Item No. **Report of the Head of Planning, Sport and Green Spaces**

Address 89 LONG LANE HILLINGDON

Development: Hip to Gable Extension, part two storey side/rear extension and single storey side/rear extension

LBH Ref Nos: **3432/APP/2014/2020**

ALL DIMENSIONS ARE IN MM AND ARE TO BE CHECKED ON SITE PRIOR TO THE COMMENCEMENT OF THE WORKS AND ANY DISCREPANCY IS TO BE REPORTED TO THE CONSTRUCTION MANAGER BEFORE CONSTRUCTION.

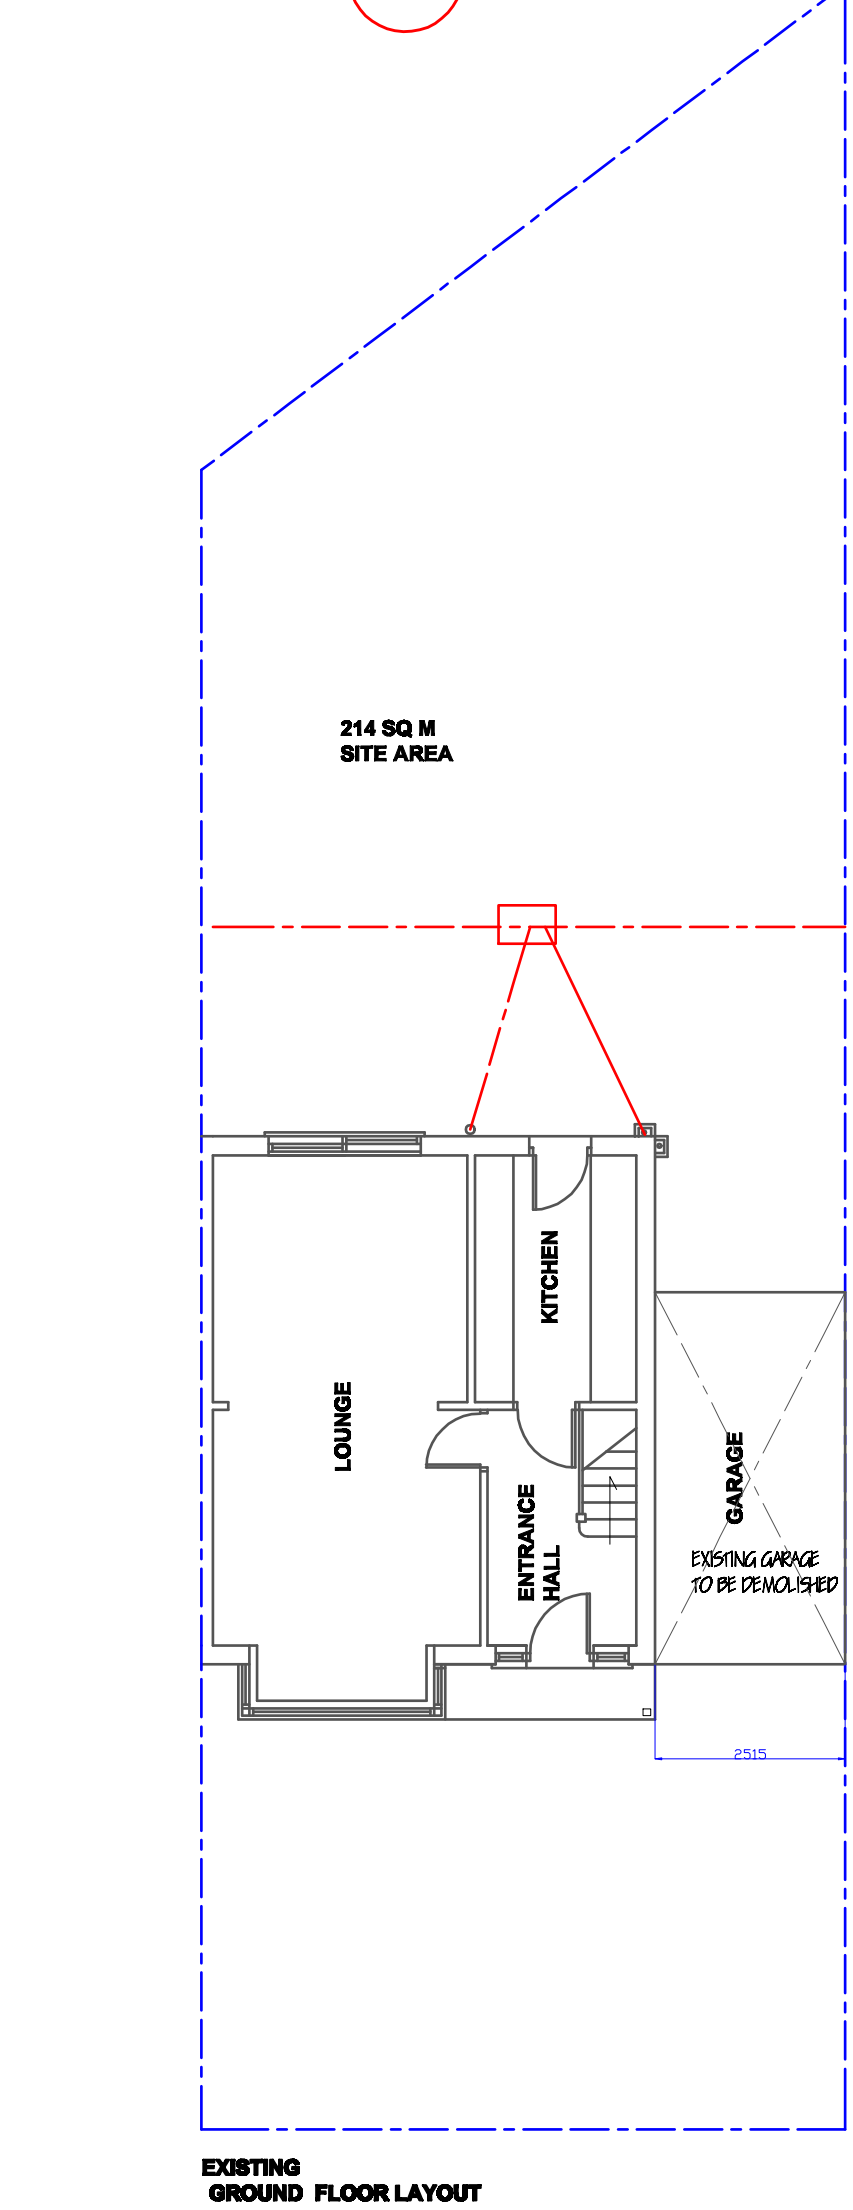
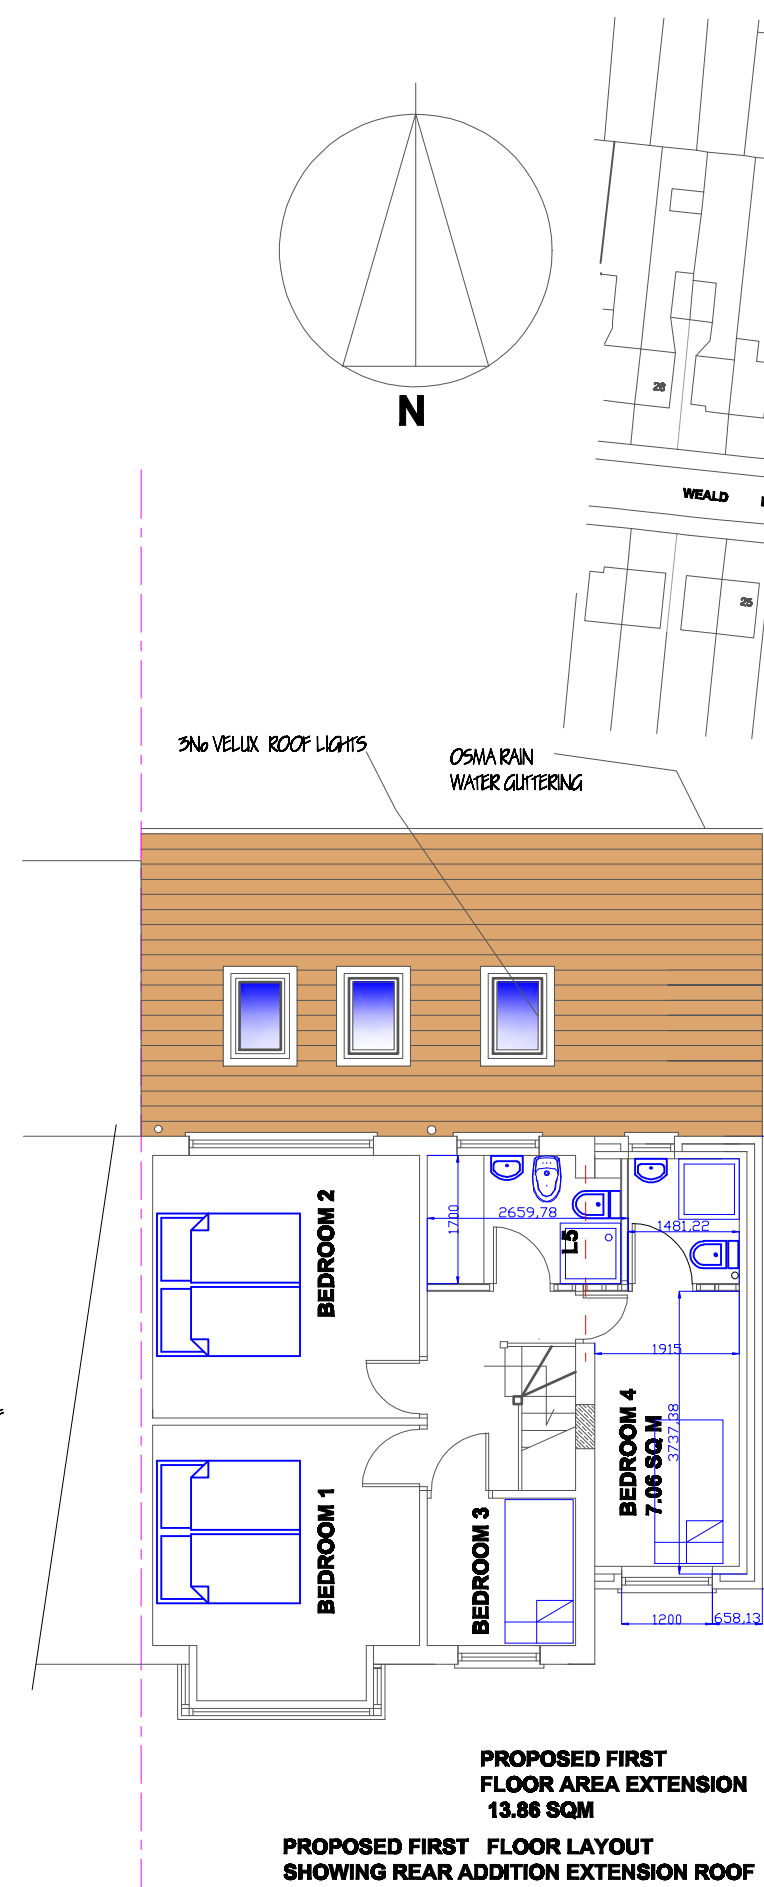
The proposed two storey side extension would not be any more than two thirds the width of the original house and would be set-back 1m behind the main front elevation of the house in accordance with this advice. However the proposal would not retain a gap of 1m to the side boundary and would result in the alteration of the main roof from a hip to a gable with a hipped roof to the extension. Even if the roof conversion is carried out as permitted development, the proposed hipped roof to the extension would be at odds with the gabled roof and would appear as an incongruous addition to the property. Moreover, the two storey side extension would only be 0.2m away from the site boundary and as a result would fail to preserve an adequate visual gap between it and the adjacent property. The two storey side extension is therefore contrary to Policy BE1 of the Hillingdon Local Plan: Part One - Strategic Policies (November 2012) and policies BE13 and BE15 of the Hillingdon Local Plan: Part Two - Saved UDP Policies (November 2012).

Paragraph 3.3 of the HDAS states that single storey rear extensions proposed on semi-detached houses with a plot measuring 5m wide or more should be no more than 3.6m deep. Likewise paragraph 3.7 states that such extensions should be no more than 3.4m in height. This is to ensure that the extension appears subordinate to the main house. The proposal marginally exceeds this advice, but is considered, on balance, to appear subordinate to the host dwelling. It is noted that the rear roof has been reduced in height from that which was previously refused to ensure the ridge sits well below the cill of the first floor windows above.

There is a first floor side facing window at No. 91 which would be affected by the proposed two storey side extension, however, as it serves a landing it is therefore considered that the proposed two storey side extension would not cause harm to the amenity of the residents at that property.

However, Policy BE23 of the Local Plan states that new residential buildings or extensions should provide or maintain external amenity space which is sufficient to protect the amenity of the occupants of the proposed as well as surrounding buildings which is usable in terms of its shape and siting. The supporting text relating to this policy emphasises the importance of protecting private amenity space and considers it a key feature of protecting residential amenity. Paragraph 3.13 of the HDAS recommends that a four bedroom house should retain at least 100sq.m of usable garden space. The proposed single storey rear extension means that only 72sq.m of rear garden space would be retained for the site,

which would be substantially below that required and contrary to policy BE23.

The proposed hip to gable extension of the host dwelling and the size, scale, bulk and design of the two storey side extension would be detrimental to the character and appearance of the original house, would result in a visual imbalance of this pair of semi-detached properties, 87 and 89 Long Lane and would be detrimental to the visual amenity of the street scene and the wider area generally. The proposal is therefore contrary to Policy BE1 of the Hillingdon Local Plan: Part One - Strategic Policies (November 2012), Policies BE13, BE15 and BE19 of the Hillingdon Local Plan: Part Two - Saved UDP Policies (November 2012) and the adopted Supplementary Planning Document HDAS: Residential Extensions.

The proposed two storey side extension by reason of its siting, size, scale, design and proximity to the side boundary, would result in a closing of the visually open gap between it and the neighbouring property, 91 Long Lane, giving rise to a cramped form of development, which would be detrimental to the visual amenities of the street scene and the surrounding area generally. The proposal is therefore contrary to Policy BE1 of the Hillingdon Local Plan: Part One - Strategic Policies (November 2012), Policies BE13, BE15, BE19 and BE22 of the Hillingdon Local Plan: Part Two - Saved UDP Policies (November 2012) and the adopted Supplementary Planning Document HDAS: Residential Extensions.

The proposed single storey rear extension would, by virtue of its failure to maintain an adequate amount of private usable external amenity space for the occupiers of the existing property, result in an over-development of the site detrimental to the residential amenity of existing and future occupiers. The proposal is therefore contrary to Policies BE19 and BE23 of the Hillingdon Local Plan: Part Two - Saved UDP Policies (November 2012) and the adopted Supplementary Planning Document HDAS: Residential Extensions.
